COLORADO KIDS RANCH  
18065 SADDLEWOOD ROAD, MONUMENT, CO 80132  
Grading & Erosion Control (GEC) Plans  
El Paso County, Colorado

GEC PLAN  
TITLE SHEET

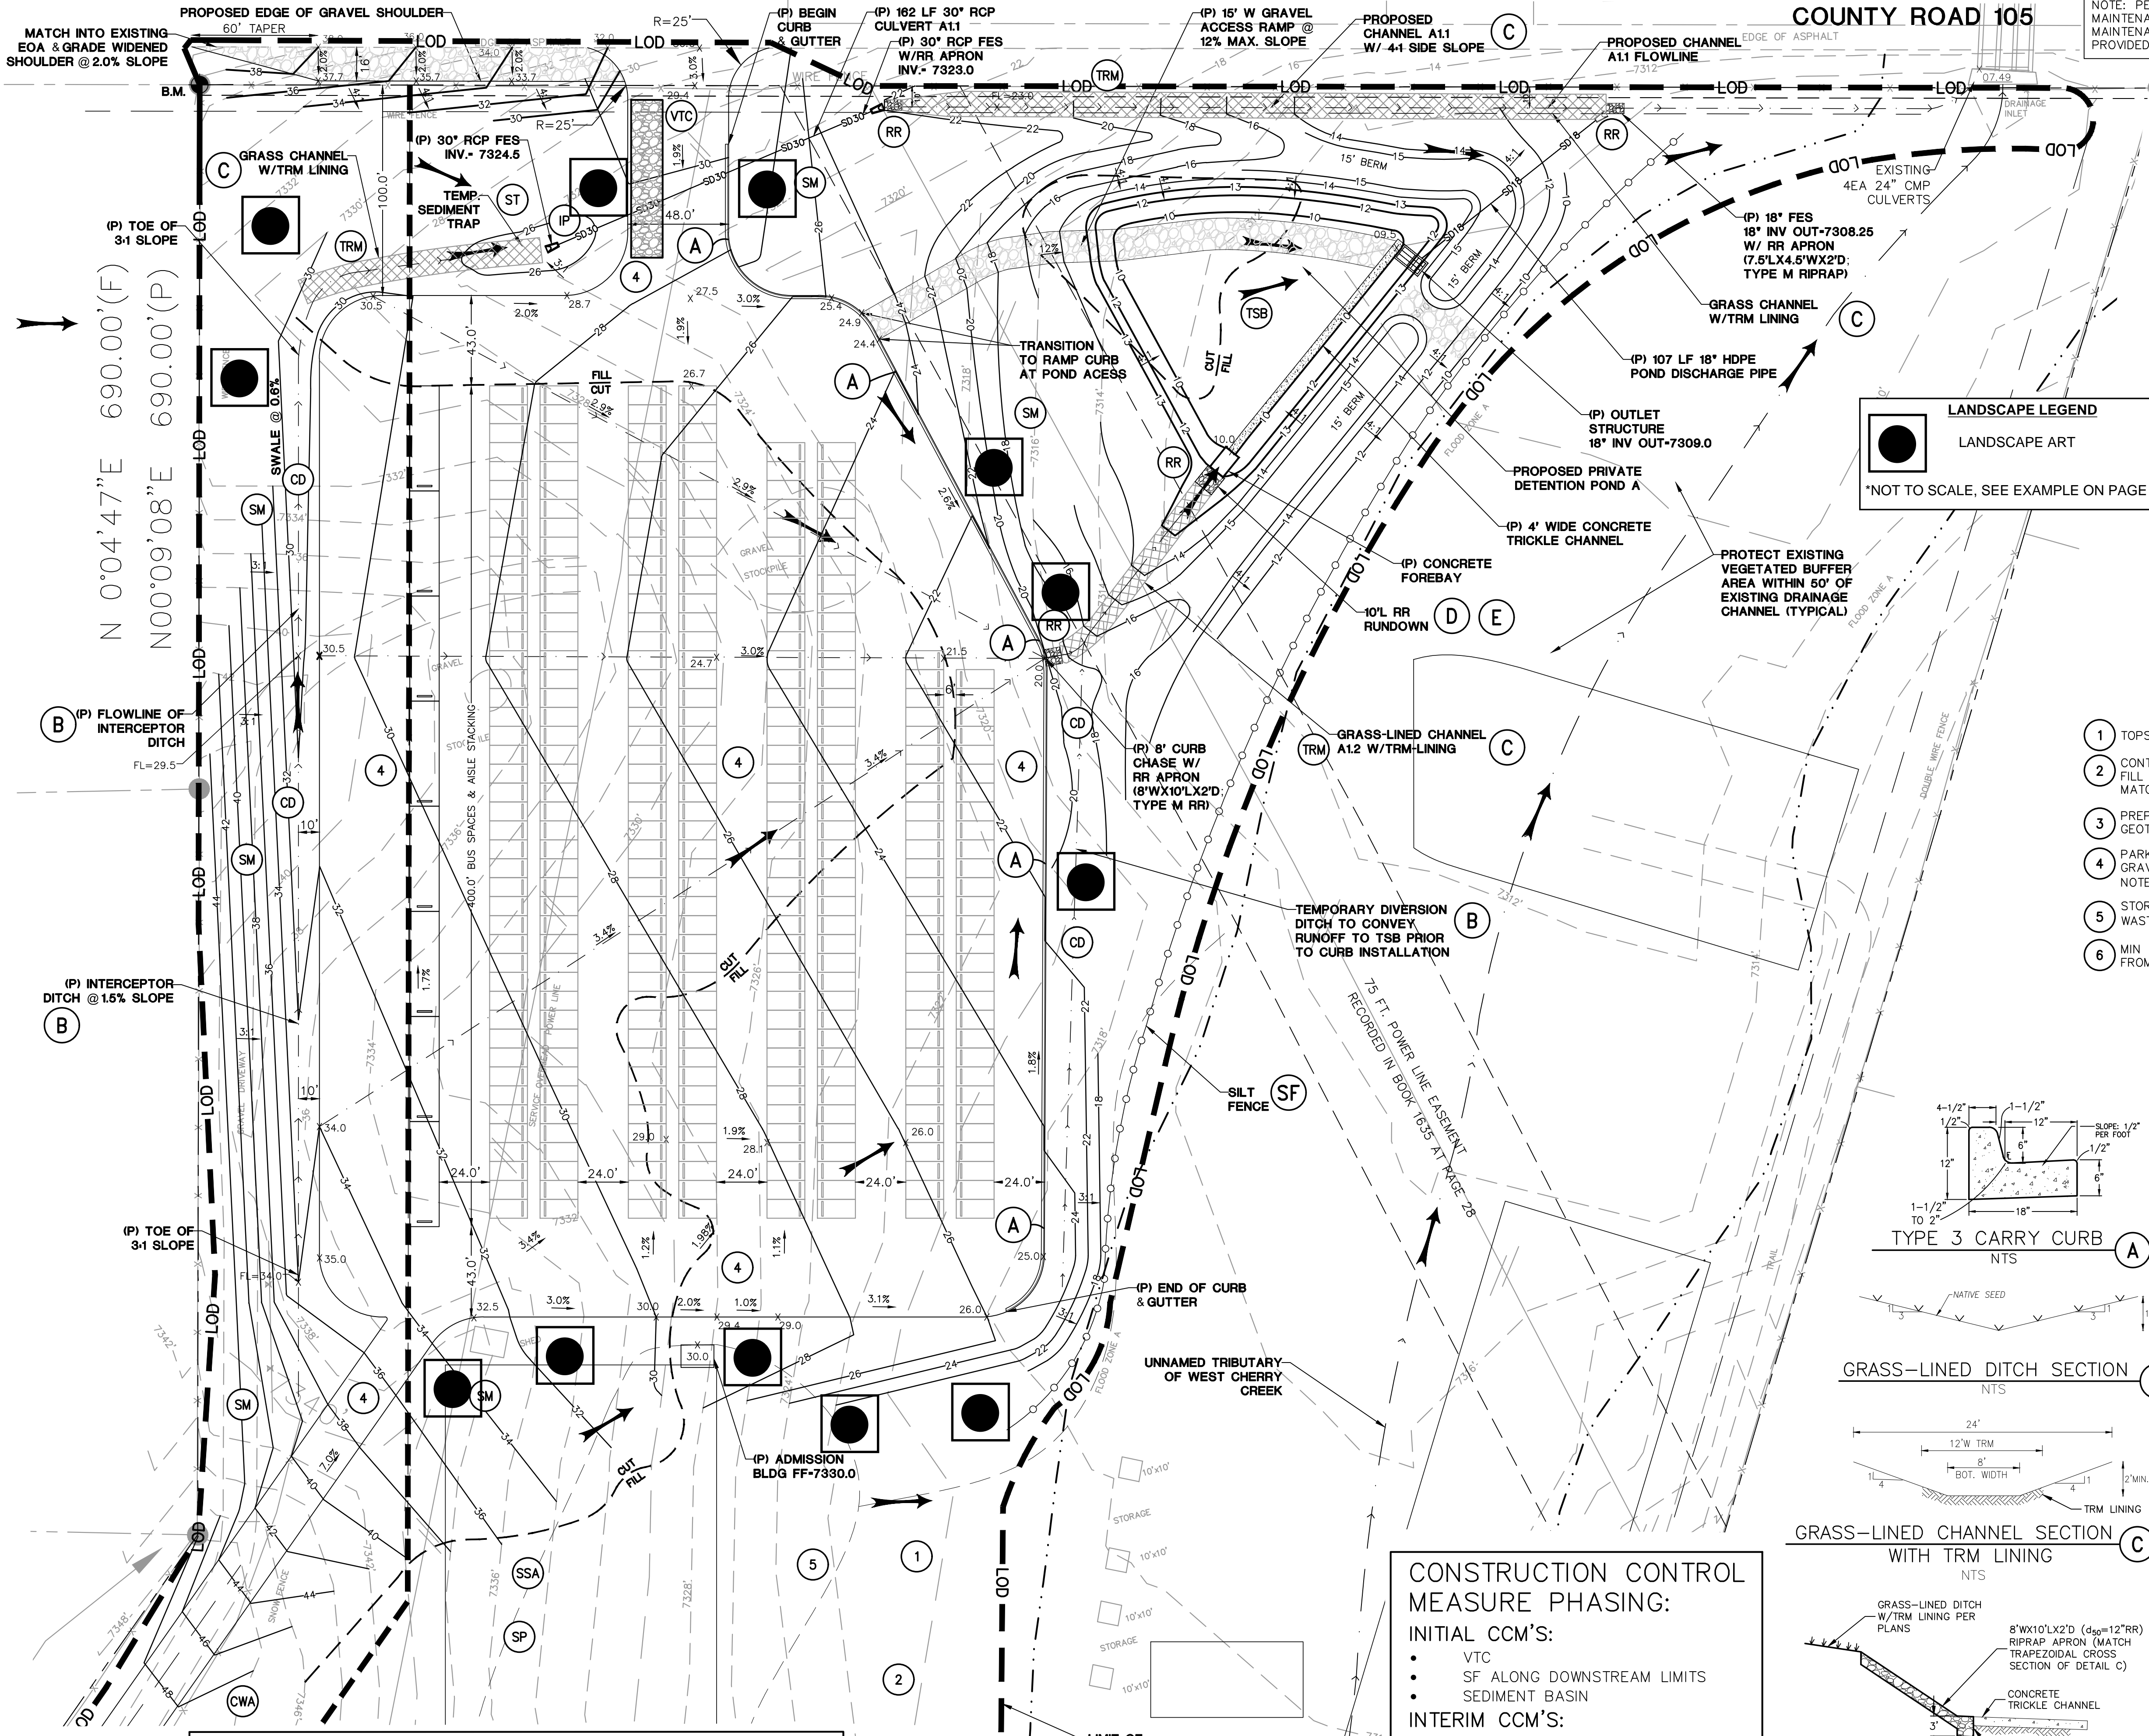
Consider need for additional temp BMPs for this basin considering the amount of disturbance there is. For example: consider a temp sediment trap here and/or temp check dams in the upstream swale

Add this hatching to the Legend

GEC Checklist Item CC - show maintenance easement for pond. Alternatively add a note to the plans to the effect of: "Note: Per standard County Detention Maintenance Agreement, a blanket maintenance easement has been provided across the property."

Provide more detail on how this RR apron connects to the forebay. Detail should show conveyance of water into forebay in a manner that prevents bypassing/erosion around sides of forebay or undercut under forebay wall, both of which we have witnessed in the field with this type of connection.  
Also, the riprap apron is v-shaped and the opening in the forebay wall is rectangular. Unless the riprap toewall acts as the transition from v-shape to rectangular. Please clarify.
